**Laurie Leader - RE: BP#2014-02356 850 Baxter Blvd. - Preliminary plan review comments**

I have begun the plan review for Seaside Rehabilitation and Health Care Center Lobby/Rehabilitation Renovation. Can you please clarify the following initial questions:

SHEET:  
**A001**

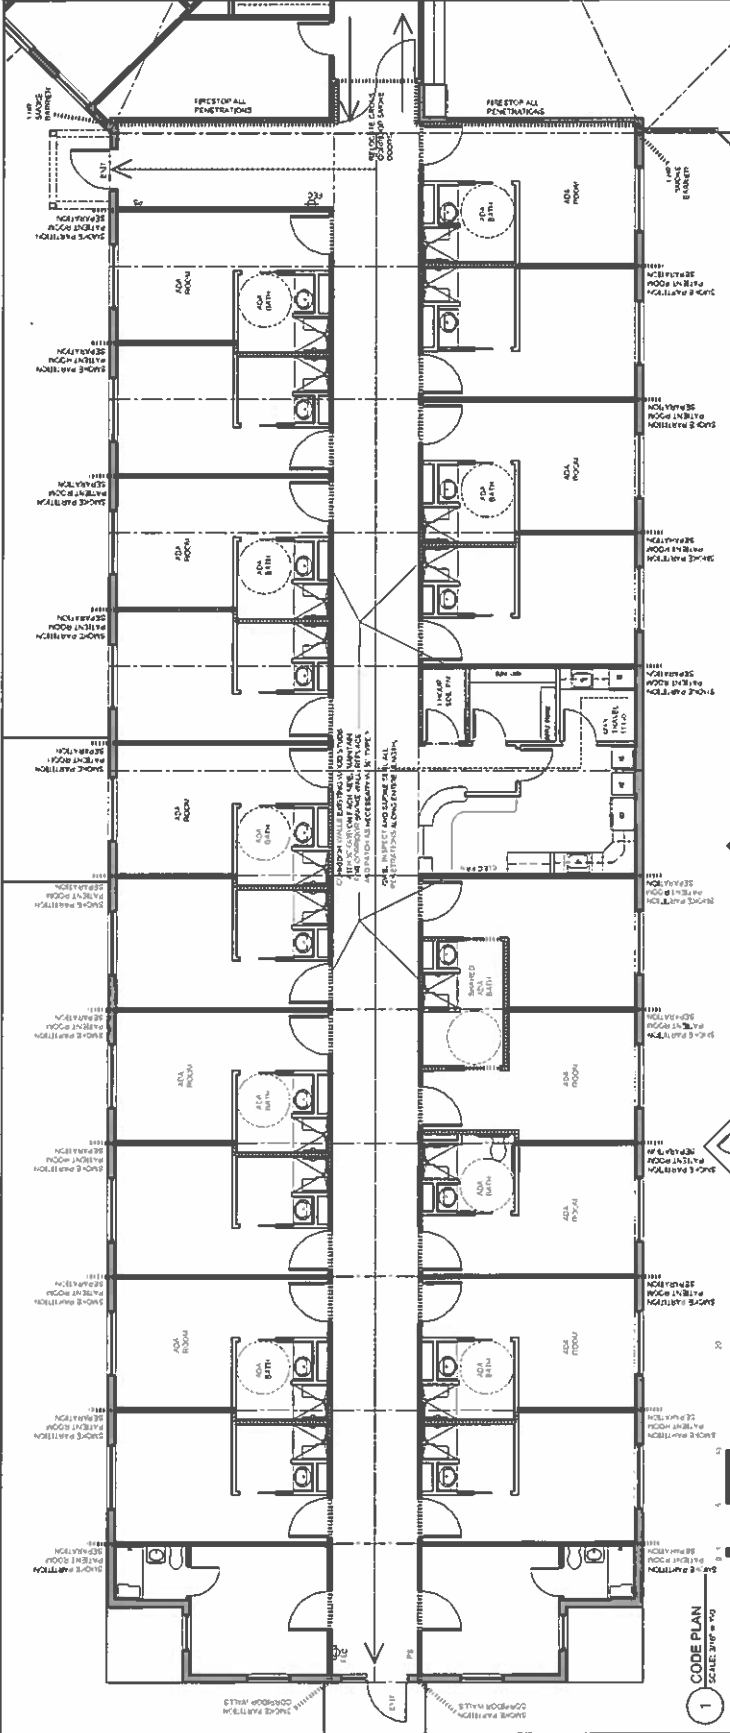
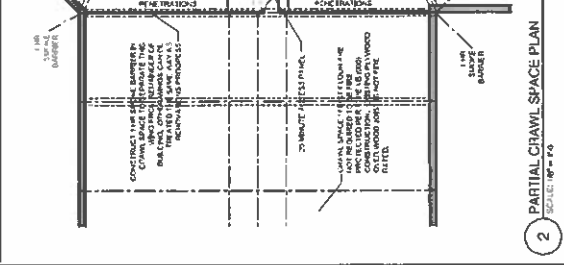
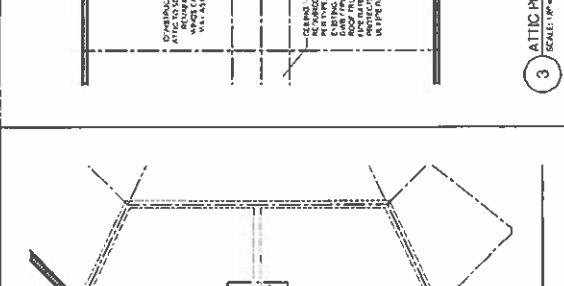
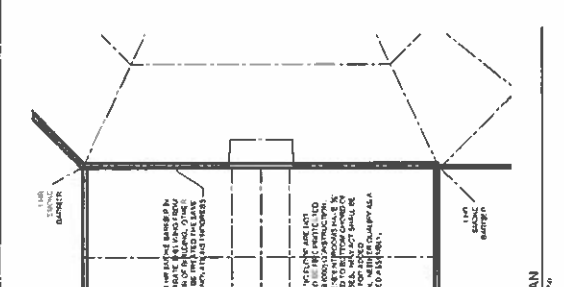
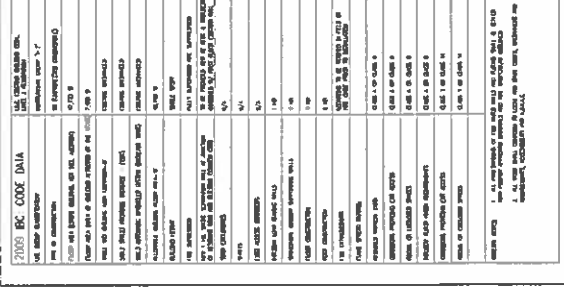
1. The occupant load for the rehabilitation center is 44 shown as persons. In your code analysis, please provide the calculations and basis for how this occupant load was arrived at. I have looked but don't see where 44 persons is shown anywhere. 42,773 sf / 240 sq ft / person equals 178 persons. **On sheet A001, in the rehabilitation center it states occupant load of 44 persons.**

3. Plan sheet A001, the egress path is shown with arrows. Please explain how the travel distance from the farthest point was arrived at. The plans state the maximum travel distance is 107 feet but it is unclear how this was arrived at and the arrows showing travel distance are unclear as one line has arrows shown in both directions. 107 feet from the office noted to the front door along the path shown. Double arrows indicate travel at cross corridor doors as required. Certainly in this building, the center core provides so many exiting options, at least 6, the exiting

The 42,773 sq ft on the drawings is the same as was shown for the previous Wing I renovation drawings. I think it was not changed to include the enclosed rehab area and account for some dimensional discrepancies we found in the base floor plan we were using. Total area should be increased to 43,737 sq ft interior space. This does not include the exterior drive under canopy or exterior patios. I assume your much larger number must include those areas.

44 is the occupant load of the rehab room in which the note is placed.
